NOTICE TO CONTRACTOR
All construction must comply with current NC Building Codes and is subject to field inspection and verification.
APPROVED
Unlimited building only review.
Permit holder responsible for full compliance with the code.
05/13/2022
[Signature]
HARNETT COUNTY
NORTH CAROLINA

The Cypress

BBH-2052

Foundation Plan

Foundation Plan

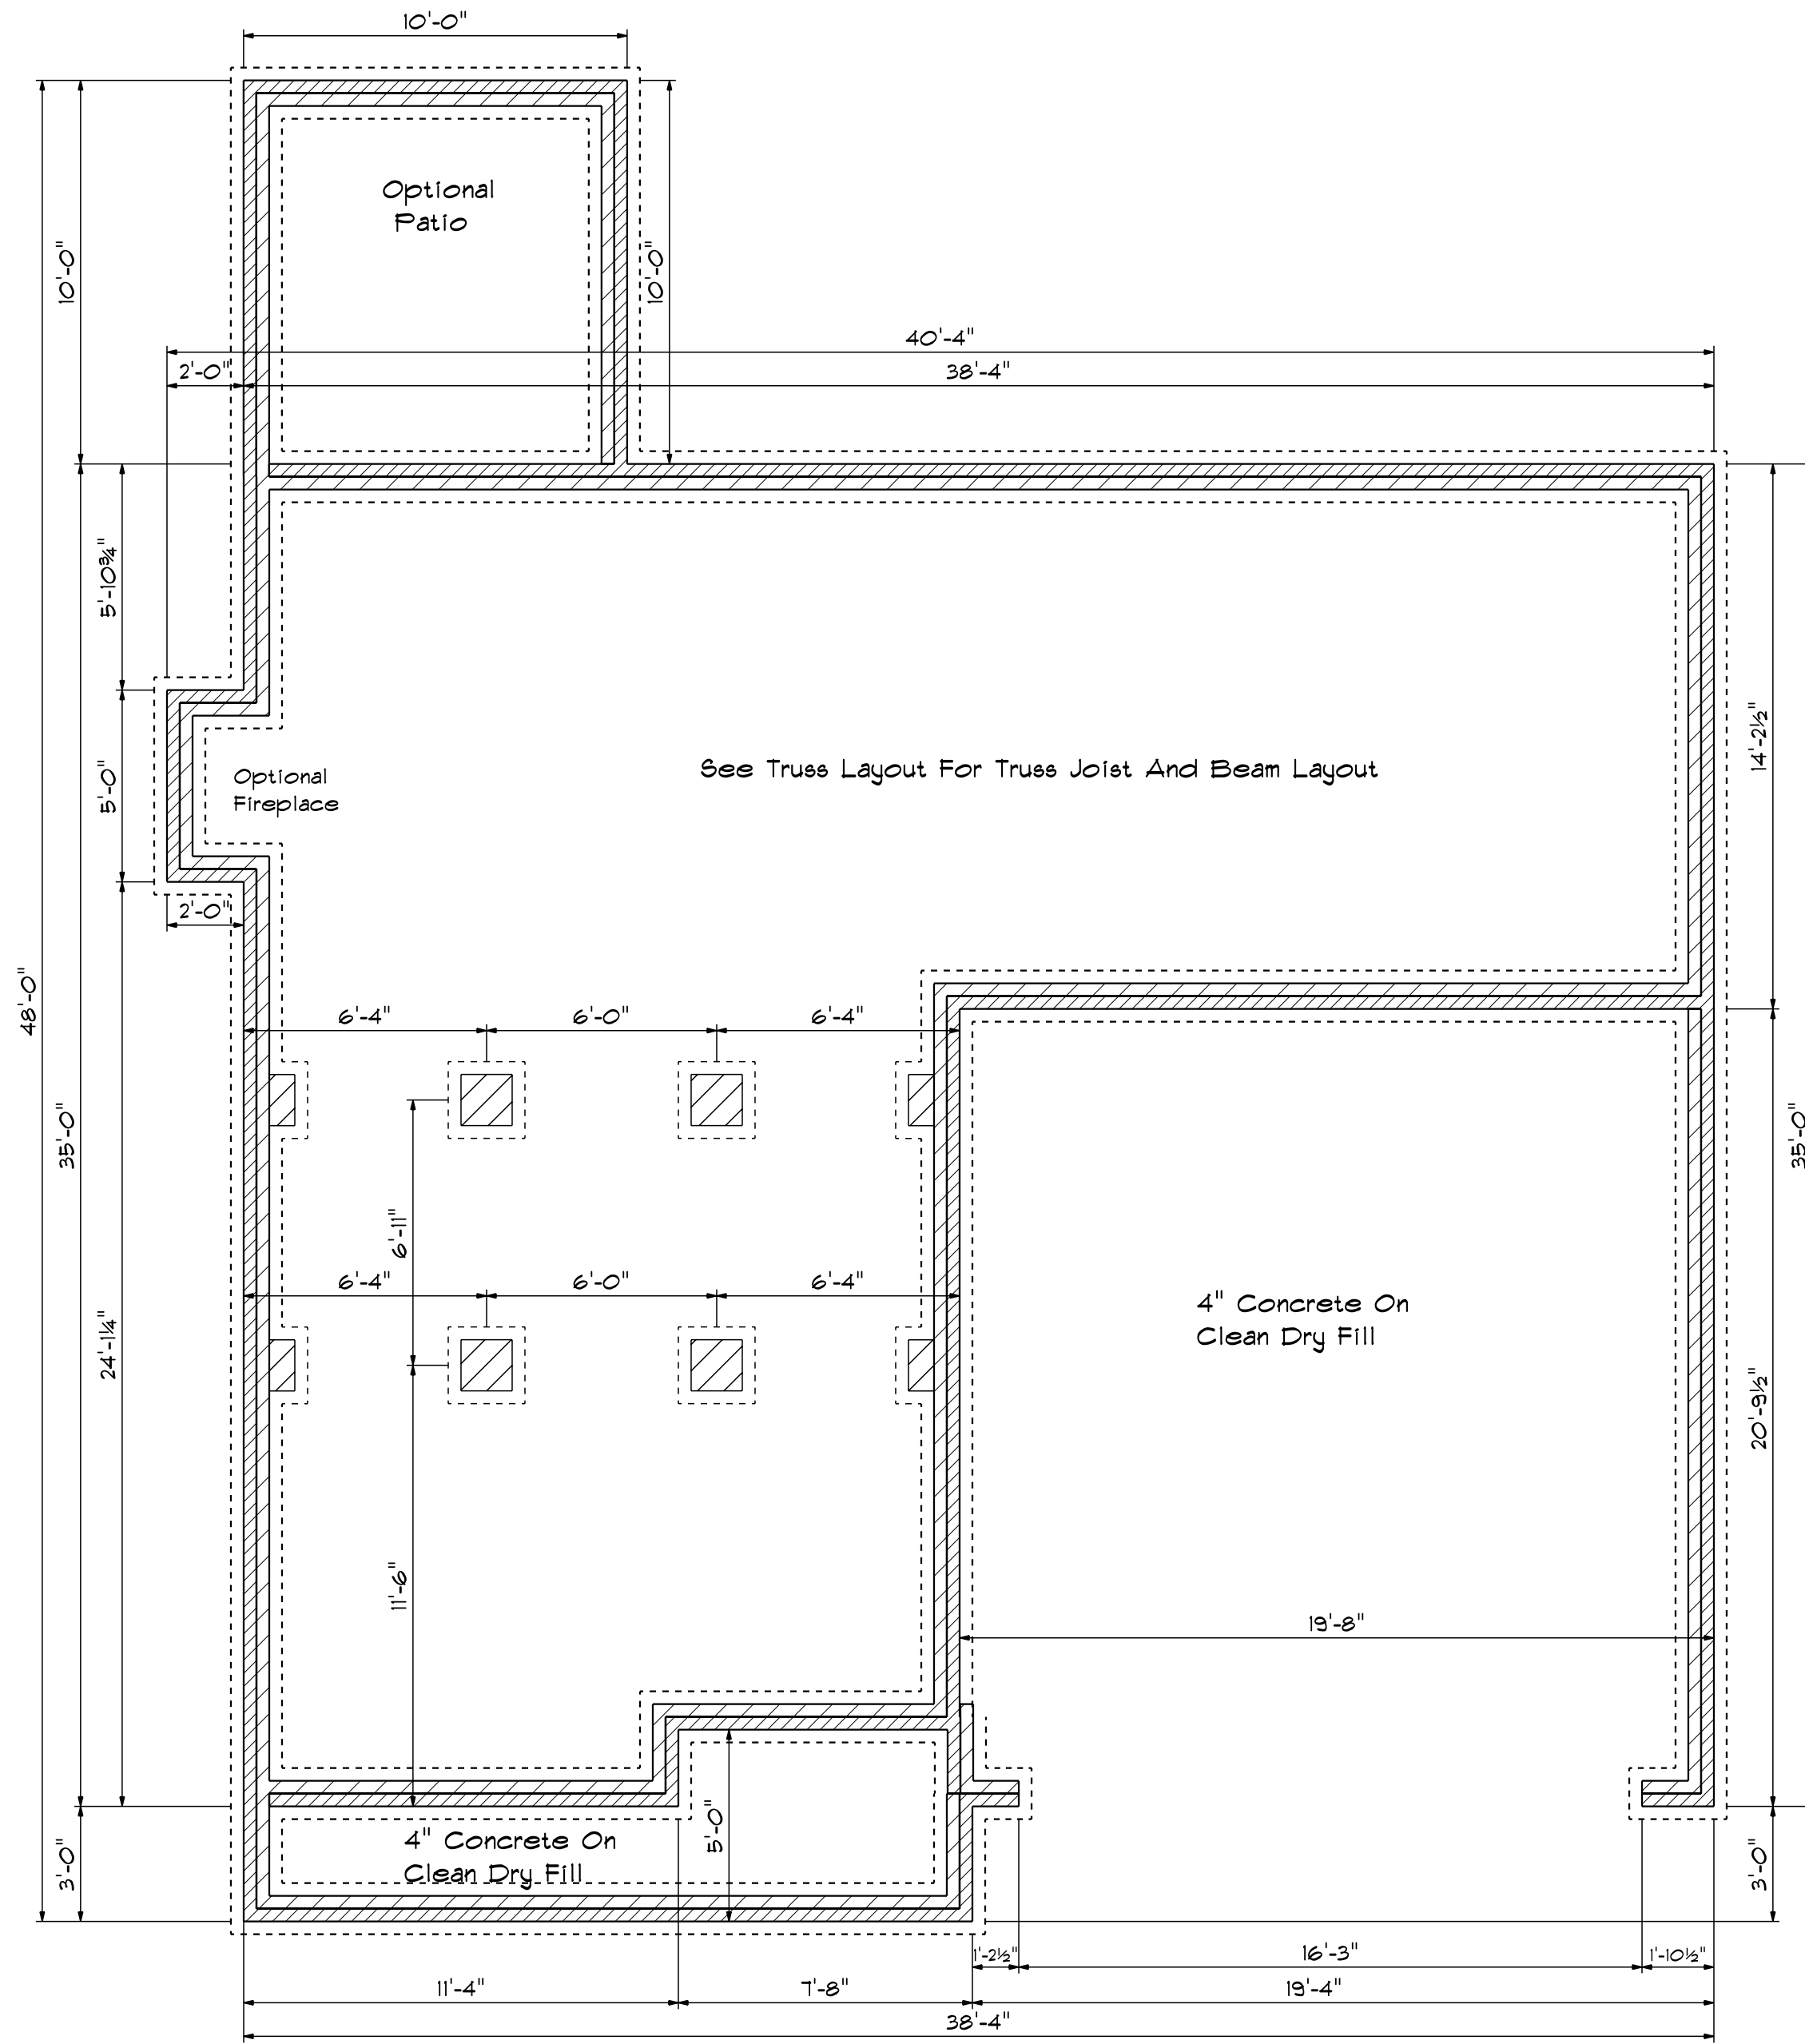
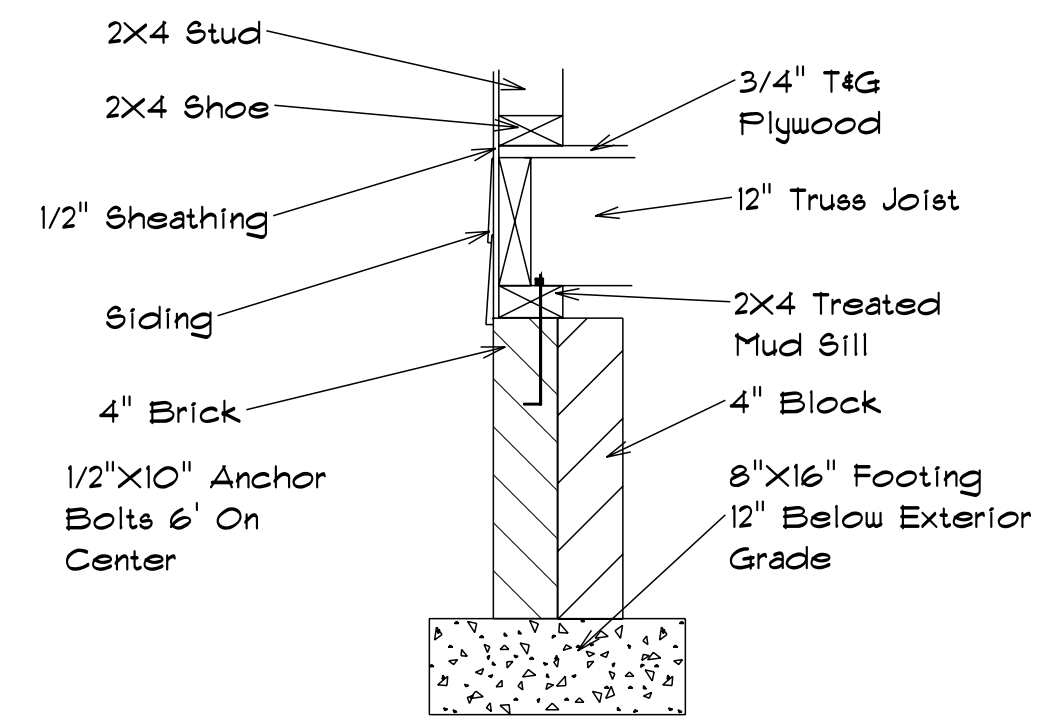
Footing must be continuous across garage door opening, or provide enlarged piers
